**Maine Investment Properties, LLC  
1651 Broadway  
South Portland, ME 04106**

**RE: Review Comments for Duplex Site Plan**

**Project Name: Maine Investment Properties Duplex**  
**Project ID: 2013-002269**  
**Project Address: 124 Veranda St            CBL:431-M-005001**

**C-100**

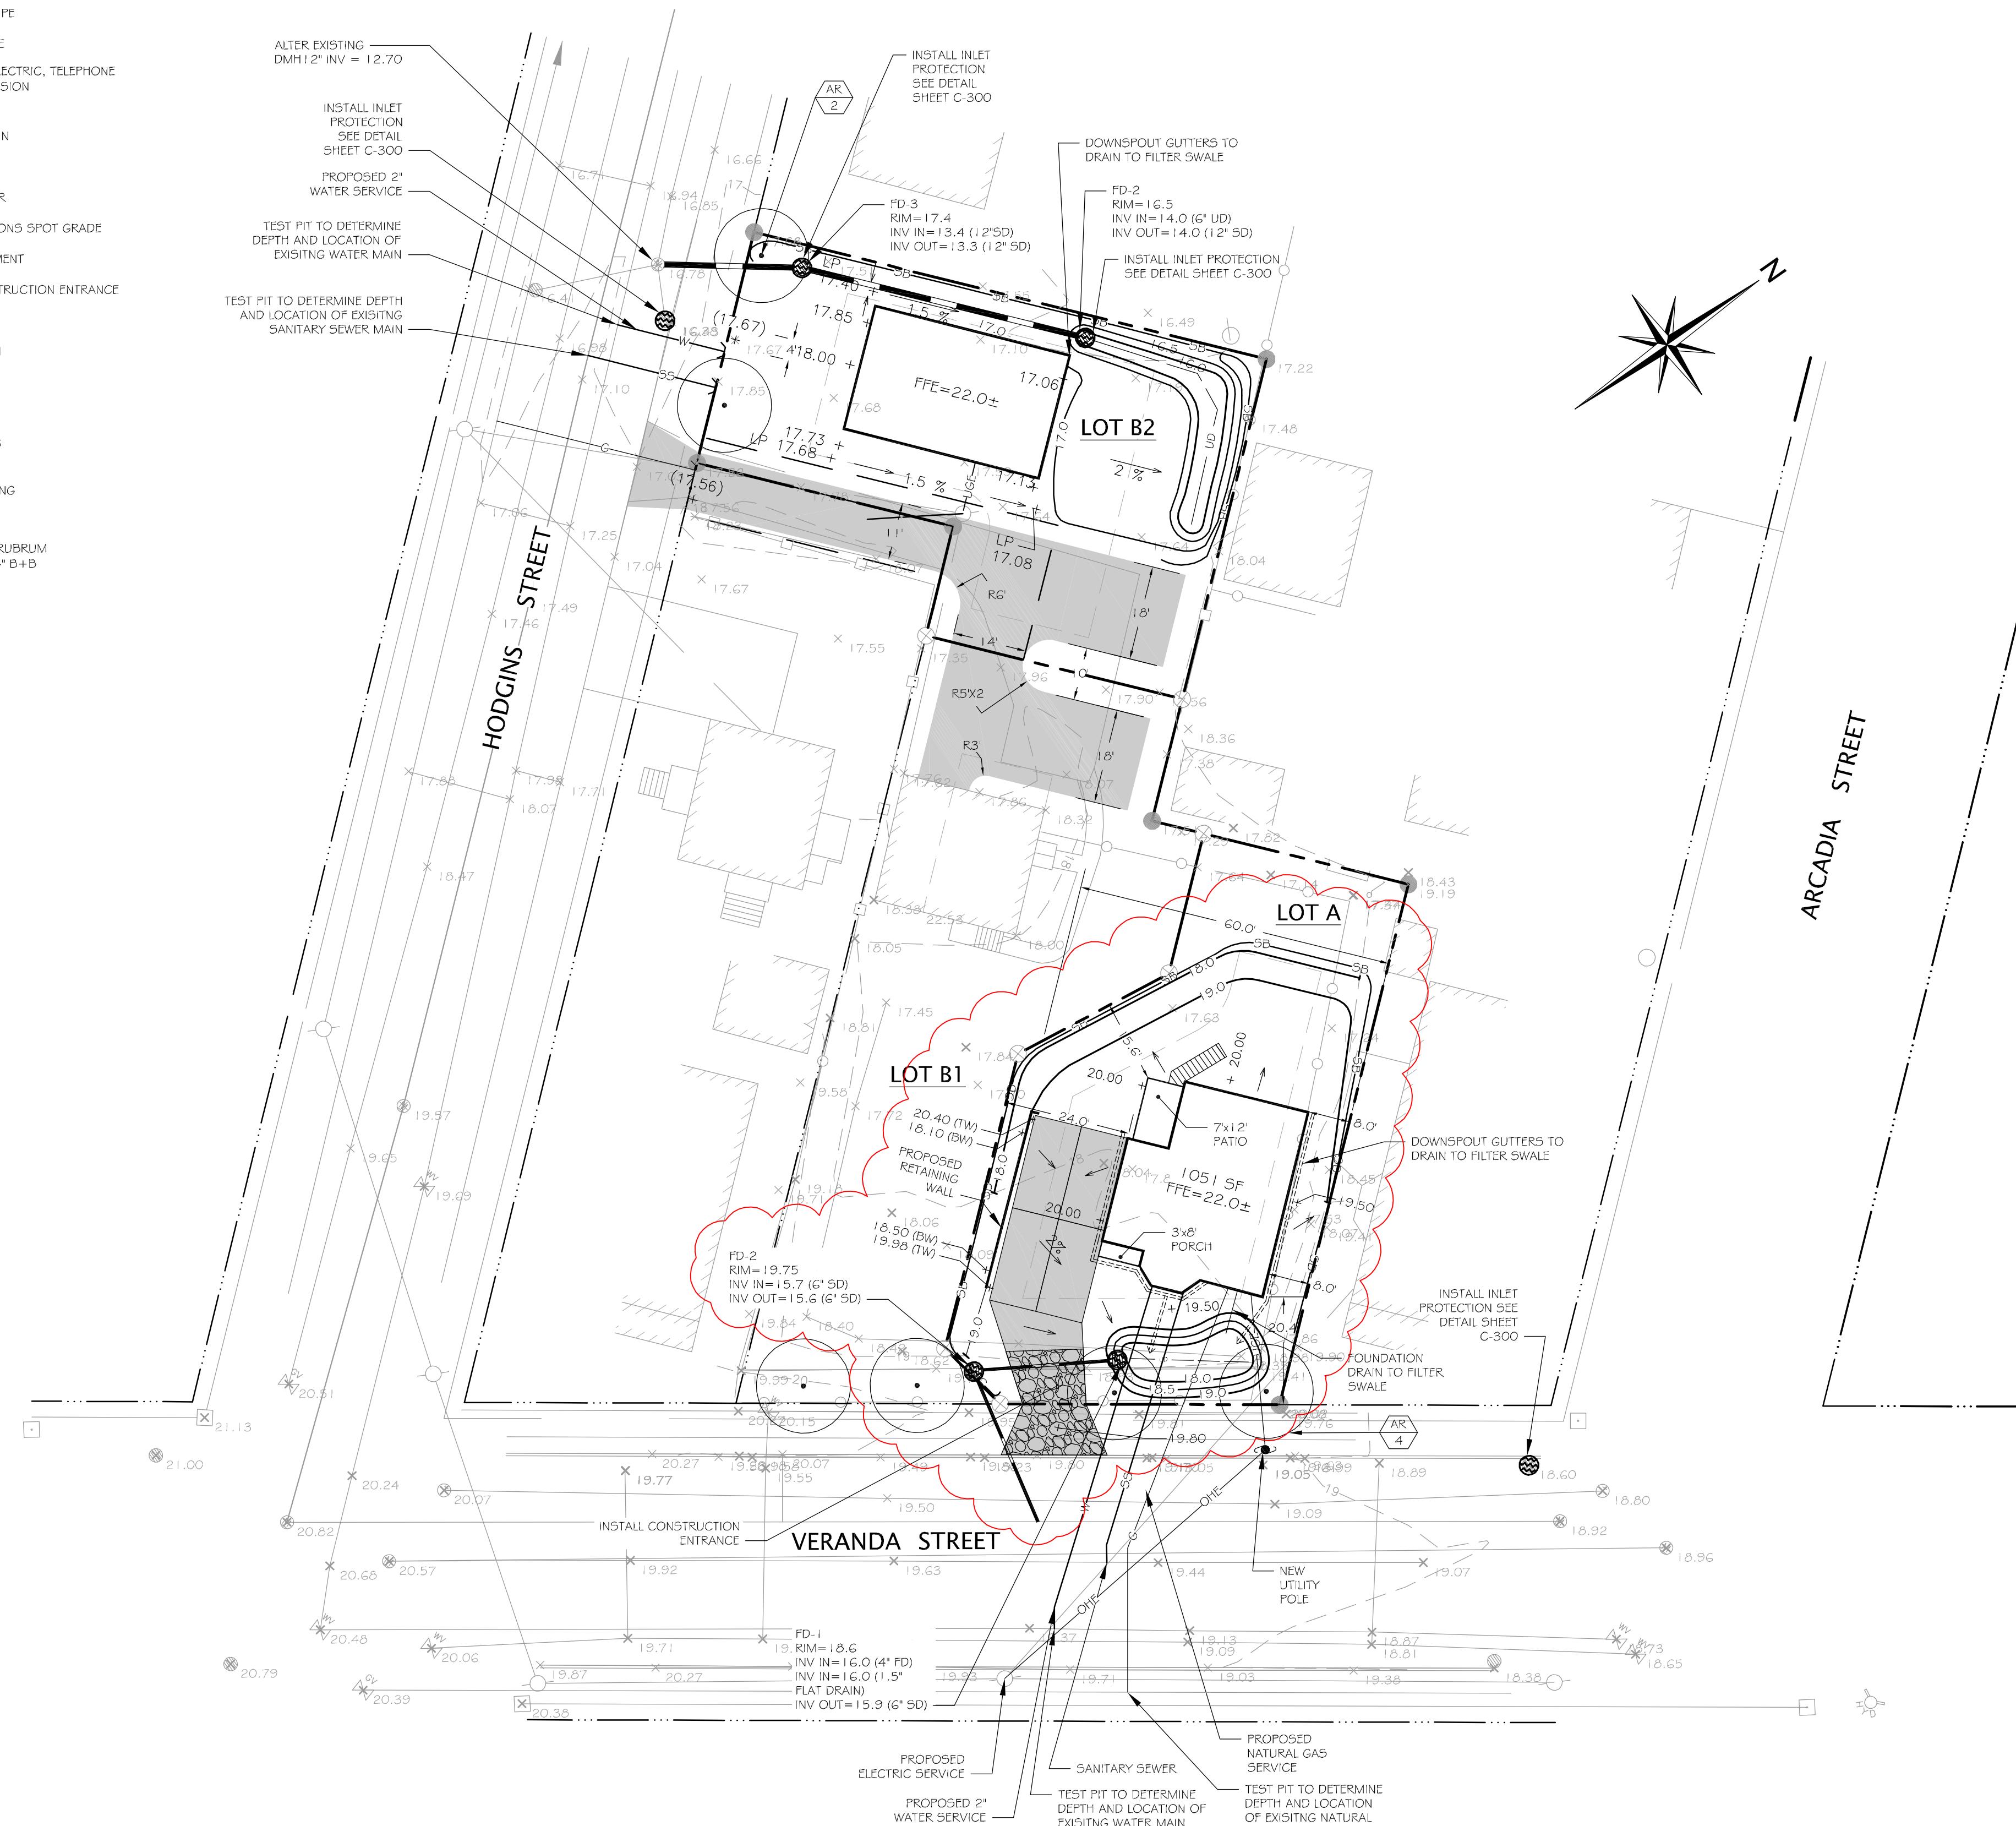
■ *Please show the existing and proposed structures, as applicable, and the distances from all property lines.*

■ *Please add the zoning district to the site plan.*

■ *Please add the ground floor area to the site plan.*

■ *Please add the locations of all proposed utilities from the street to the structure, to the site plan.*

■ *Please add the soil type to the site plan.*

■ *Please show on the site plan where the foundation drain will outlet.*

■ *Drainage Manhole 2 – (DMH-2) appears to be located on the property line of Lot B1 and Lot A, and the drain line to DMH-1 appears to cross lot B1. Please submit a utility easement that grants you rights to cross lot B1 with the drainage line, and to locate DMH-2 partially on Lot B1 as shown on the submitted site plan; or revise the plan to make it clear that all improvements to the site will take place exclusively on Lot A.*

■ *Please submit a revised site plan that includes the following information: The footprint on the site plan by Steve Blais, needs to delineate between the footprint of the porches and decks on the structure and the principal structure.*

Response: Distances between the proposed structure and the property lines were added to the site plan.

Response: A note including the zoning district was added to the site plan under the general notes.

Response: A note stating the ground floor area was added to the site plan under the general notes.

Response: Proposed utilities have been added accordingly.

Response: A note stating the soil type was added to the site plan under the general notes.

Response: The foundation drain is shown on the site plan and will outlet into the proposed filter swale.

Response: An easement has been established as shown on the updated survey plan and that recorded utility easement(I-100) is included with this letter.

Response: The proposed structure on the site plan was revised to show the location and size of a porch and patio.
